Gatwick Northern Runway Development Consent Order Application TR020005

Reigate & Banstead Borough Council 20044474

**Principle Areas of Disagreement Summary Statement (PADSS)
Version 2 Deadline 2 Submission Clean Version**

26 March 2024

Project Code-Location-Discipline-Volume-Type-Unique Number
41700- XX -B- LLO- GA - 200172 P02

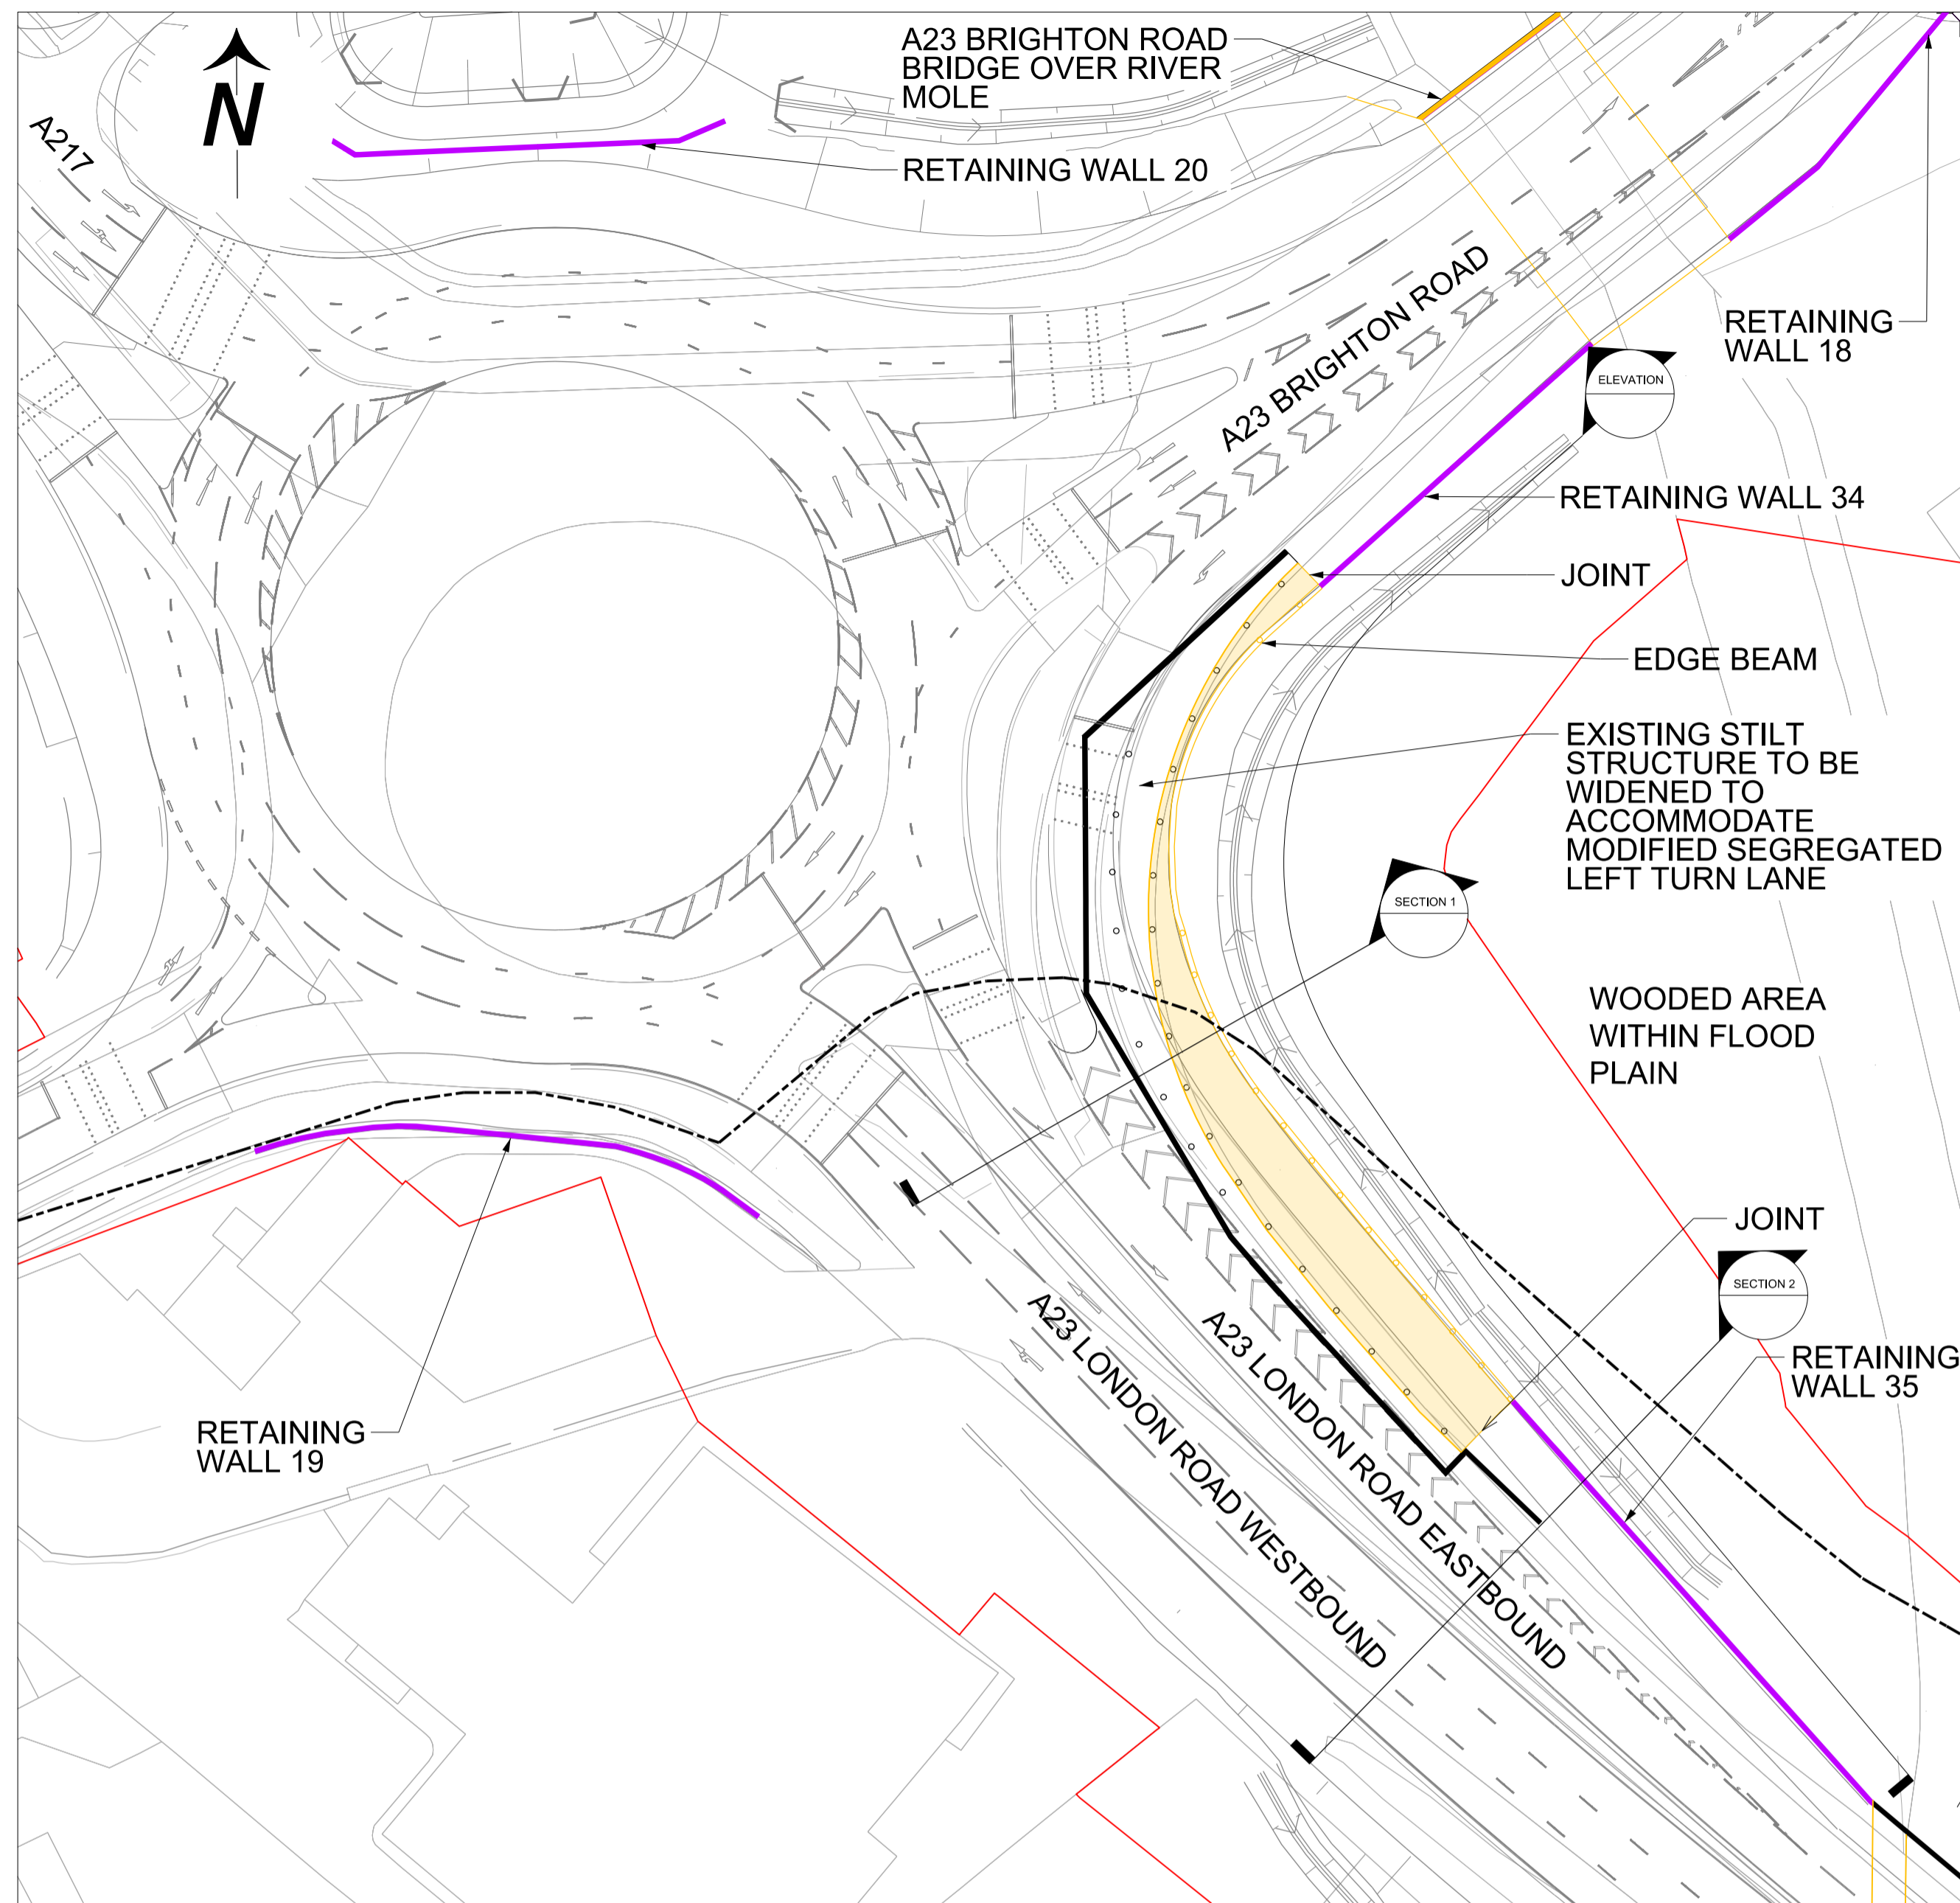
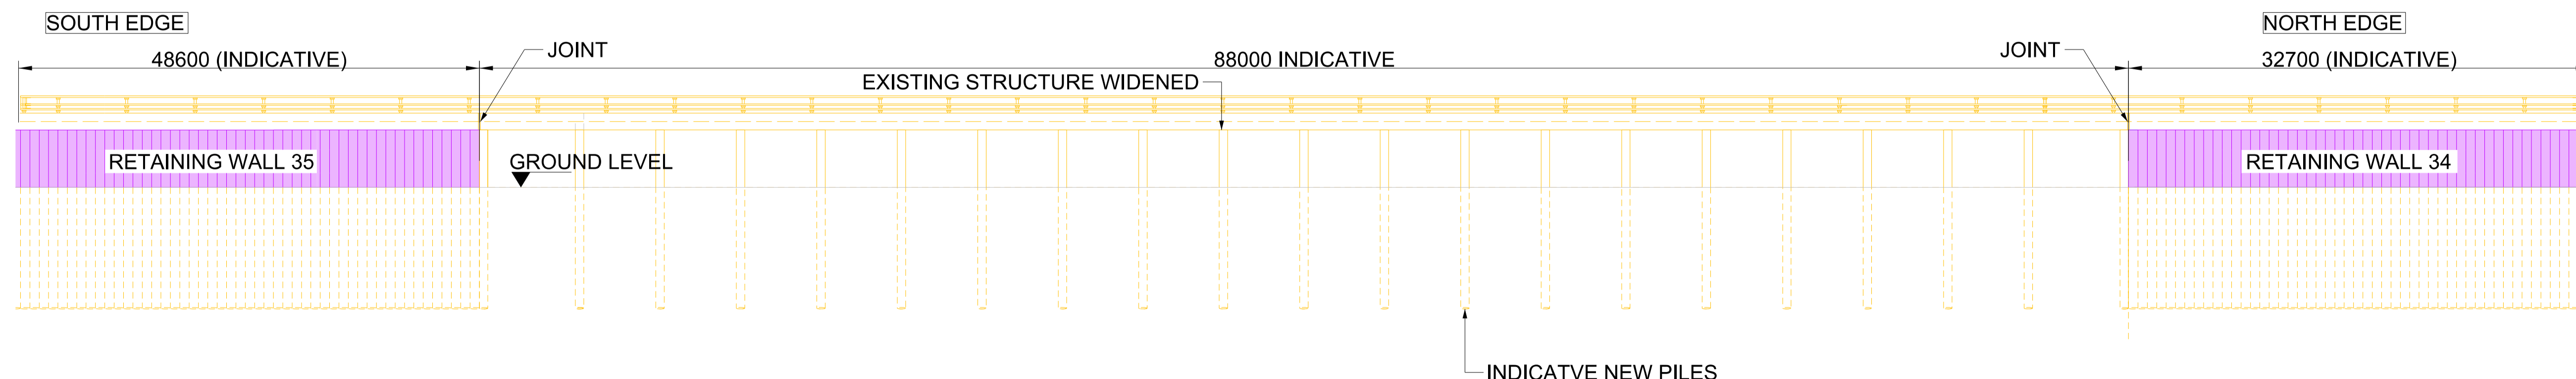
benefitting from having an enlarged Gatwick on their doorstep. Following Socio-Economic Topic Working Group meeting on 12th December 2023 and Issues Tracker response 3.29 continue to wait for a detailed Implementation Plan	
	HISTORIC ENVIRONMENT			
8.	Impact of the A23 London Road/River Mole bridge and road widening on the Listed St Bartholomew's Church and conservation area and historic Church Meadows	Relates to the visual impacts of the works on the listed church and conservation area	Consideration of alternatives to reduce land take from Church Meadows. Issues Tracker 7.15 response states alternatives considered.	Uncertain
	ECOLOGY			
9.	The extent of loss of mature broadleaved	It is not clear from the application document how much woodland is being lost and how much is being enhanced / replanted. The same is true for	The applicant should quantify losses and	Likely
